## **OXFORDSHIRE COUNTY COUNCIL'S RESPONSE TO CONSULTATION ON THE FOLLOWING DEVELOPMENT PROPOSAL**

**Application no:** 21/01630/OUT

**Proposal:** Outline planning application for residential development (within Use Class C3), open space provision, access, drainage and all associated works and operations including but not limited to demolition, earthworks, and engineering operations, with the details of appearance, landscaping, layout and scale reserved for later determination

**Location:** Land at North West Bicester Home Farm, Lower Farm and SGR2  
Caversfield

DRAWING TITLE  
**PROPOSED PEDESTRIAN CROSSING TO CHURCH**

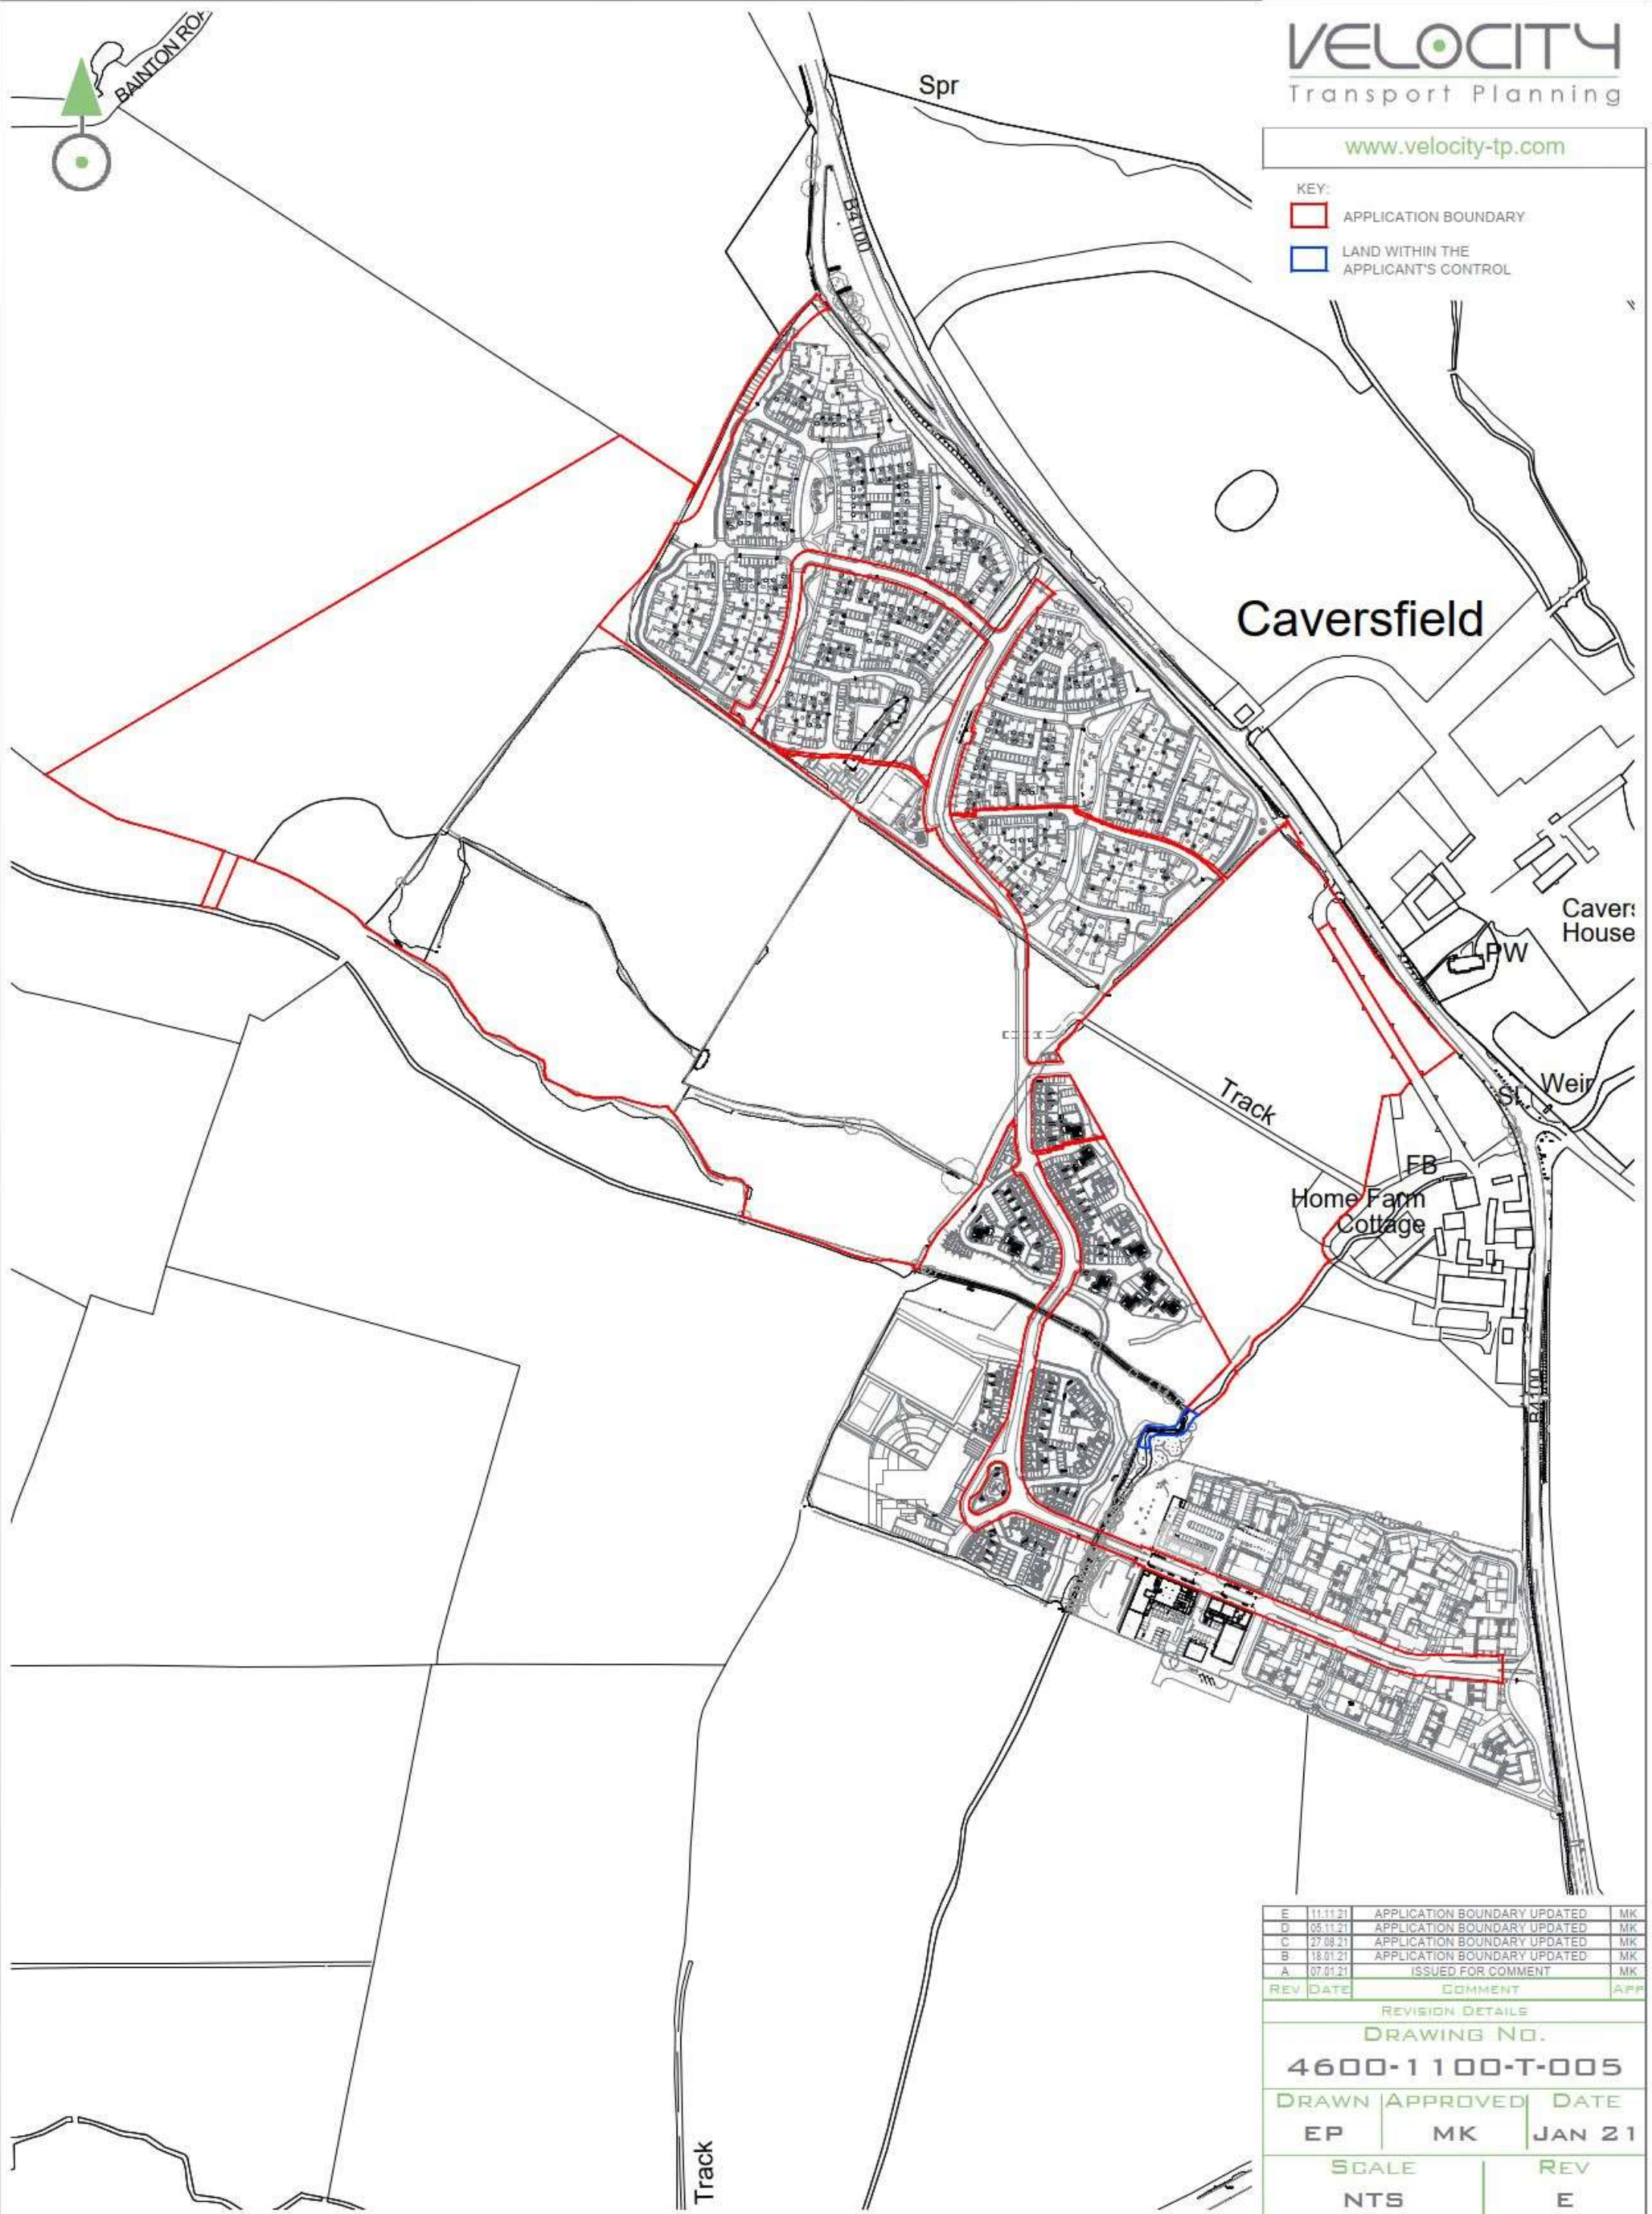
It is noted that no allowance has been made for the crossing to Caversfield Church specifically, although there is an amount of £199,996 for 'local road improvements' – clarification is required as to what this refers to.
